Ref: AW/296/17/HH

We being the owners of 27 Willowhale Avenue further object to the above planning application

AW/296/17/HH regarding the following issues:-

2.0 SUN STUDY DIAGRAMS
21ST March at 10.00am and 12.00pm

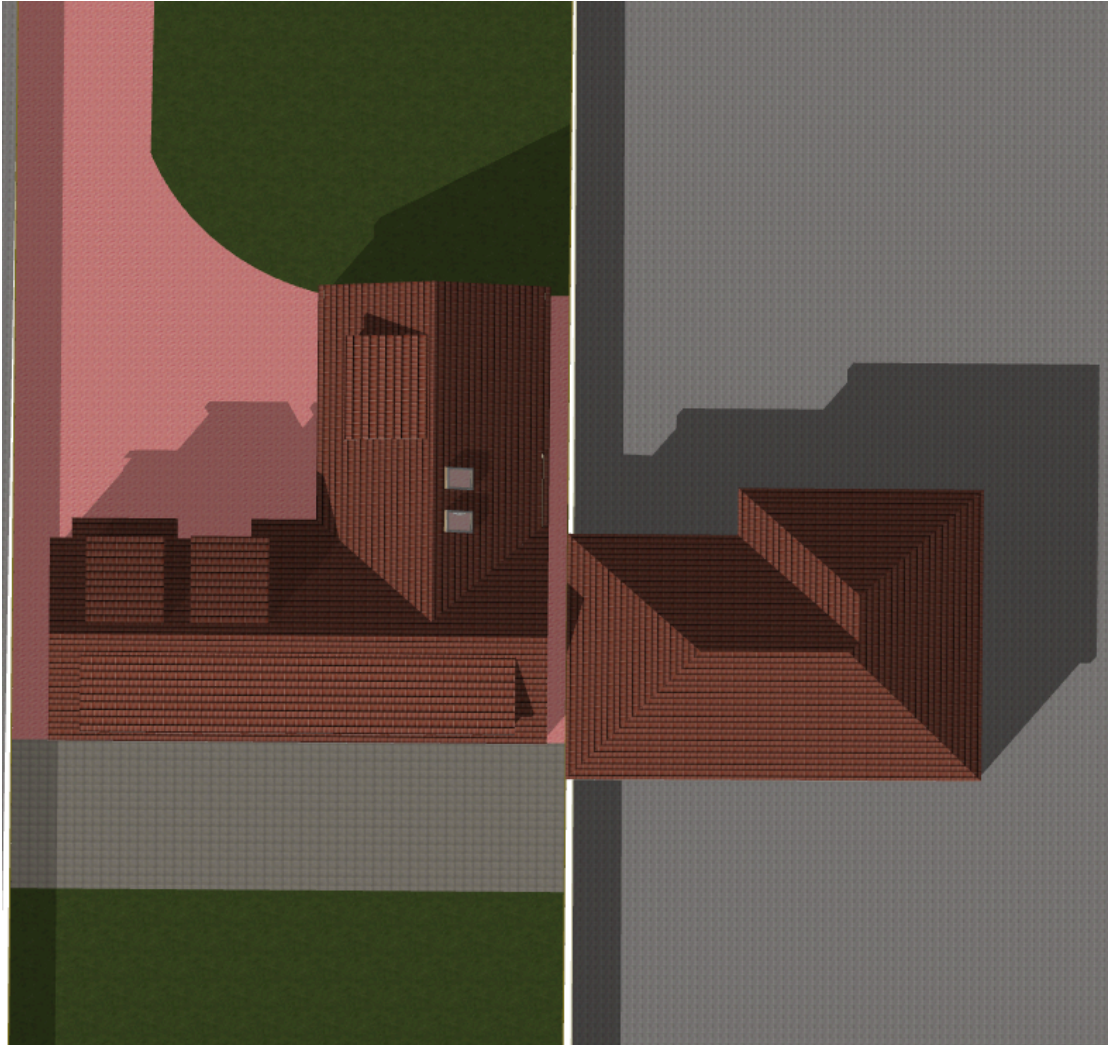
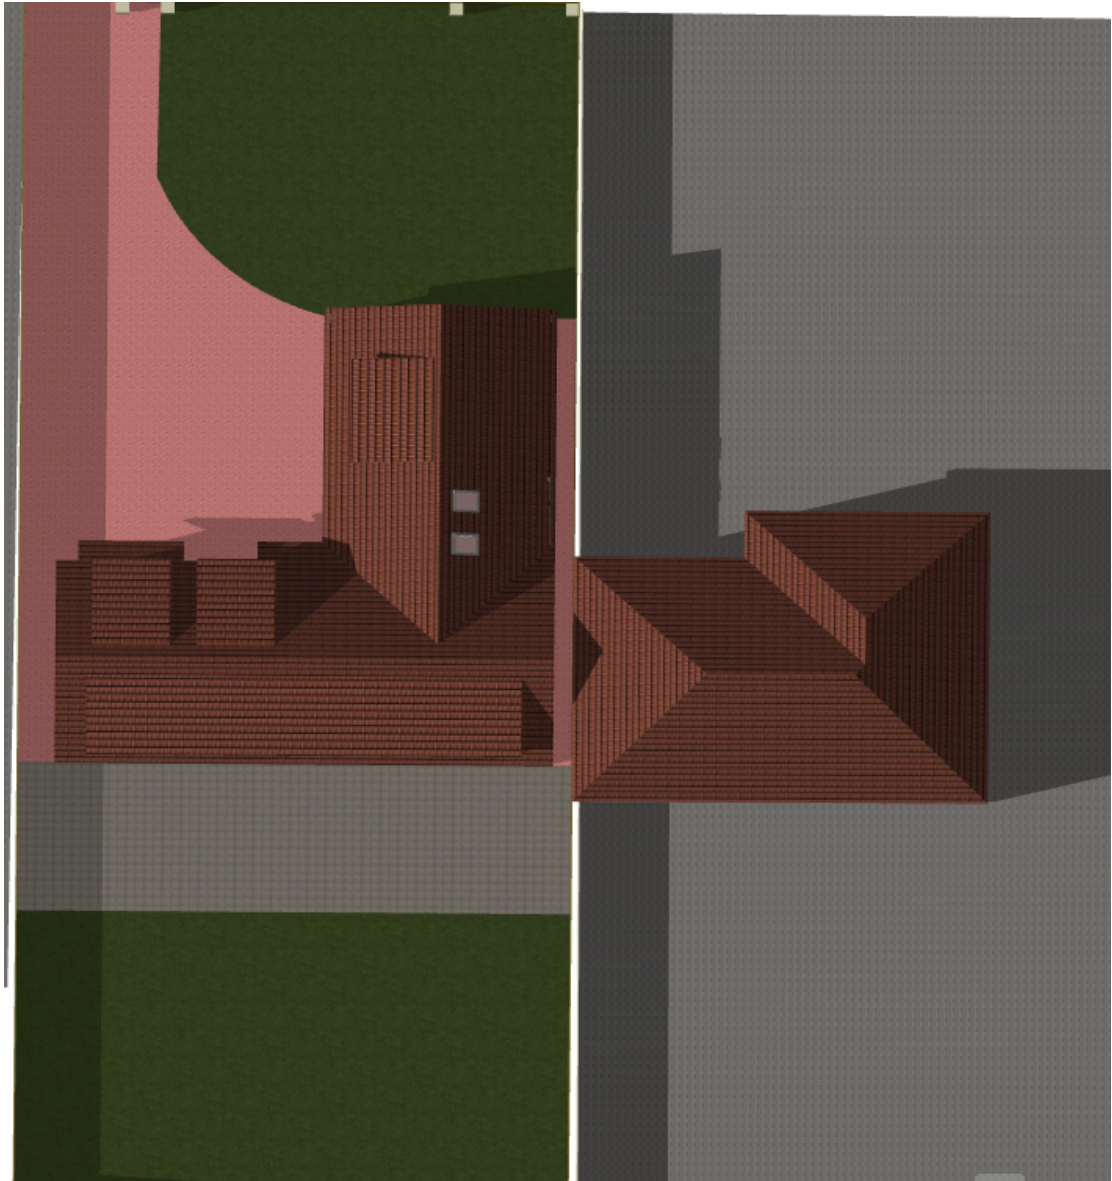
1. The submission of the Bre report for daylight and sunlight the sun study diagrams are very misleading and appear to show the proposed roof line as much lower than number 27 this will not be the case as they are almost level.
2. The increase in floor space of this proposal shows approximately 75% which will be mainly located to the front of the property.
3. If this application is mistakenly granted we will seek legal action under the Rights to Light To obtain an injunction and damages.
4. We suggest a site visit should be undertaken to see the problem this development will cause.
